Rezoning Transportation Analysis

Petition Number: 2021-125

Date	Description
09-17-2021	First Review (WLB)

Rezoning Site Plan

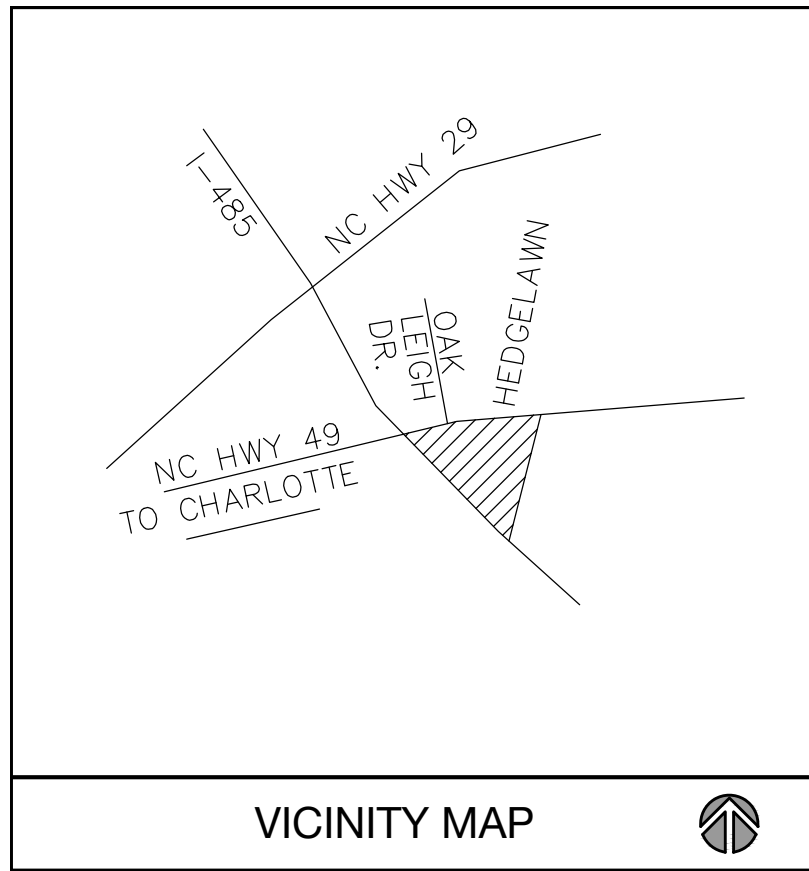
Label and dimension the future curb and gutter from the centerline for each road on the site plan.

3. Site plan and conditional note(s) revisions are needed to commit to construct bicycle facilities by installing a 12' multi-use path with an 8' minimum planting strip on the site side of University City Boulevard from Harris Houston Road signal east to eastern property line, and the north side of University City Boulevard from Harris Houston Road, east to Hedgelawn Drive and west to Halton Park Drive. in accordance with the City Charlotte BIKES Policy. Site plan should depict, label and dimension proposed and existing transportation facilities on both sides of University Blvd, including labeled intersecting streets.

4. Site plan and conditional note(s) revisions are needed to commit to installing bike and pedestrian crossing to include ADA compliant Curb ramps and pedestrian signals on both sides of the University City Boulevard at Harris Houston Road intersection in accordance with the City Charlotte BIKES and Charlotte WALKS Plans. Petitioner to coordinate with the University City Blvd/Harris Houston signal Project to ensure that the Z-crossing and proposed ADA facilities will accommodate the 12-foot multi-use path.
5. Site plan and conditional note(s) revisions are needed to extend Abercromby Street to proposed Public Road 2 per the Subdivision Ordinance.
